ADC PARKS & GREENSPACE ARBORICULTURE

PLANNING APPLICATION: A/146/14/TC

ADDRESS: St Margrets Church Arundel Road Angmering BN16 4JS

BRIEF DESCRIPTION: Reduce height and spread of 1No. Silver Birch by up to 6m, ensuring that pruning is restricted to branches of no more than 70mm diameter within the Angmering Conservation Area.

Birch tree

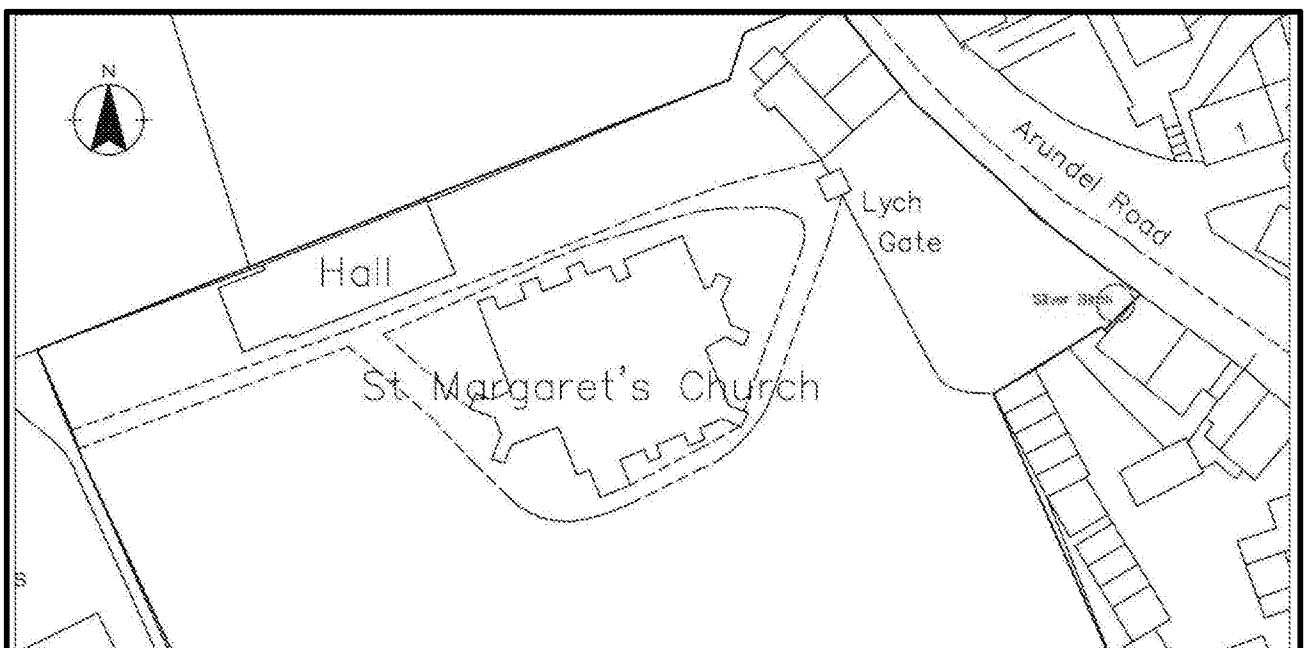
- The outlined tree is located in the front car park of Angmering church. The surrounding landscape has a reasonable mix of mainly semi mature/mature specimens.
- This individual is in a very public location, and can be easily seen from the main highway outside.
- From the site inspection it is clear that this tree has been reduced historically. The previous pruning points coincide with a height/vertical reduction of about 6 meters and a side/lateral reduction of up to 2 meters. It is also clear that some of the top western extremities of the crown are overhanging and active chimney. This does pose a real fire hazard (especially once the birch has gone dormant)
- Also to reduce back to these established pruning points, is unlikely to have a long term impact on the individual's health, aesthetic value and longevity.

- It would be therefore my **recommendation that a pruning activity should be allowed to place** as it has been done historically. The

dimensions of this **reduction should be a maximum of 6 meters of the vertical height, and also a 2 meter lateral reduction.** This would ensure this operation did not contravene the BS 3998:2010 section 7.6.

- Also a of this nature reduction will elevate the problem of overhanging branches over an active chimney and therefore reduce the risk of fire damage to the tree and neighbouring dwelling.

The Crown Reduction should not exceed the removal of single branch lengths which are greater than **1m** from the periphery of the original crown diameter. The branch removals should leave healthy substantial leaf bearing side branches. All side branches to be retained should be at least **1/3rd** in diameter of the removed branch. Pruning cuts must be flat and smooth, kept as small as possible by cutting at an optimum angle and should not exceed **100mm** in diameter.
